Rezoning Transportation Analysis

Petition Number: 2020-086

General Location Identifier: Tax ID 04708214

Date	Description
07-22-20	First Review
10-26-20	Second Review
11-30-20	Third Review

RZ-3.0

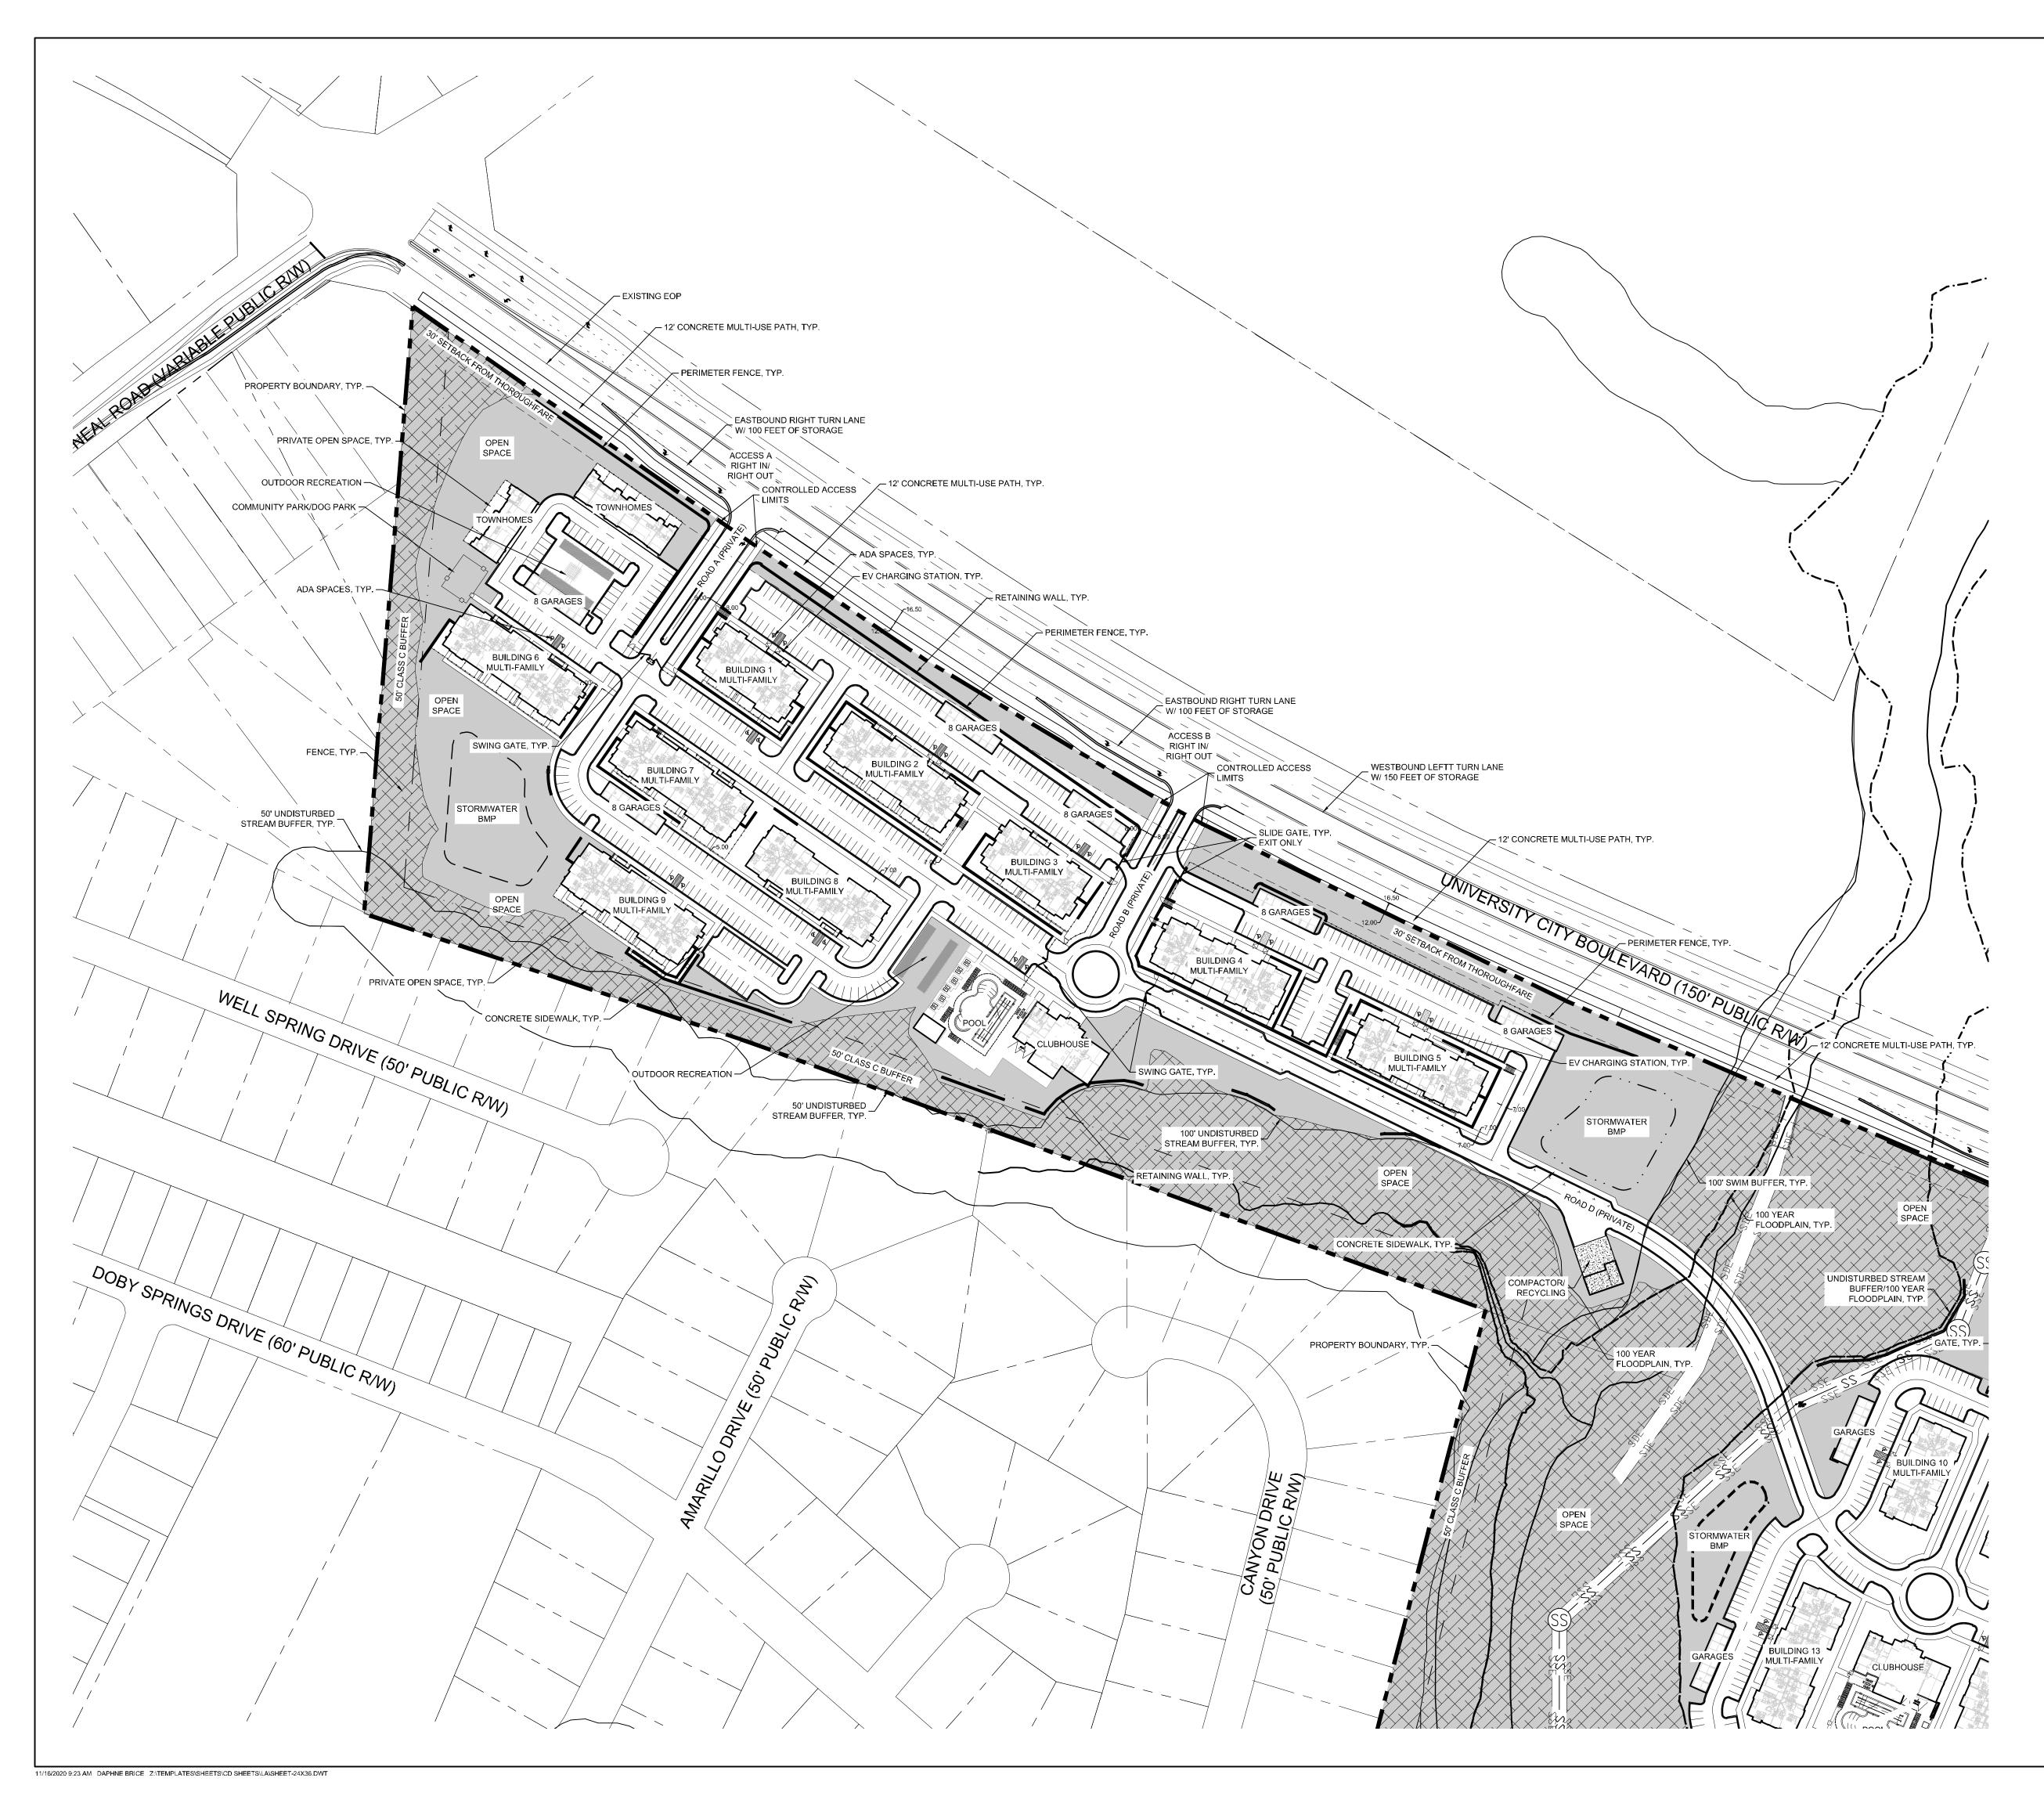
- The petitioner should revise the site plan and conditional note(s) to commit to installing a 12' multi-use path along the site's frontage on University City Blvd to meet the City Charlotte BIKE Policy.

- The petitioner should revise the site plan and conditional note(s) to commit to constructing a shared use path from Doby Springs Drive including a structure over Doby Creek to provide pedestrian and bicycle access to adjacent subdivision in accordance with the Charlotte WALKS Plan and Charlotte BIKES Plan.

- Revised Comment (site plan dated 10/12/2020)** Revise the site plan and conditional note(s) to commit to constructing a **Public street shared use path** connection to Mineral Springs Road, including a box culvert over Doby Creek, to improve connectivity by providing a north-south connection to access University Blvd.

- The petitioner should revise the site plan to add a note specifying dedication and fee simple conveyance of all rights of way to the City before the site's first building certificate of occupancy is issued. CDOT requests right of way set at 2' behind back of sidewalk where feasible.

- The petitioner should revise the site plan to add a note specifying all transportation improvements will be approved and constructed before the site's first building certificate of occupancy is issued. The petitioner may phase transportation improvements if said improvements and phasing are explicitly described in site plan notes.

- New Comment (site plan dated 10/12/2020)** The petitioner should revise conditional notes Section C.7.(a),(b), and (c) and Section C.8.(a),(b), and (c) to match the improvements listed within the latest TIS, received 09/29/20. The conditional notes should include phase 1 and 2 improvements, with scenarios A and B, as shown within Figures 12A, 12B, 13A, and 13B of the TIS.
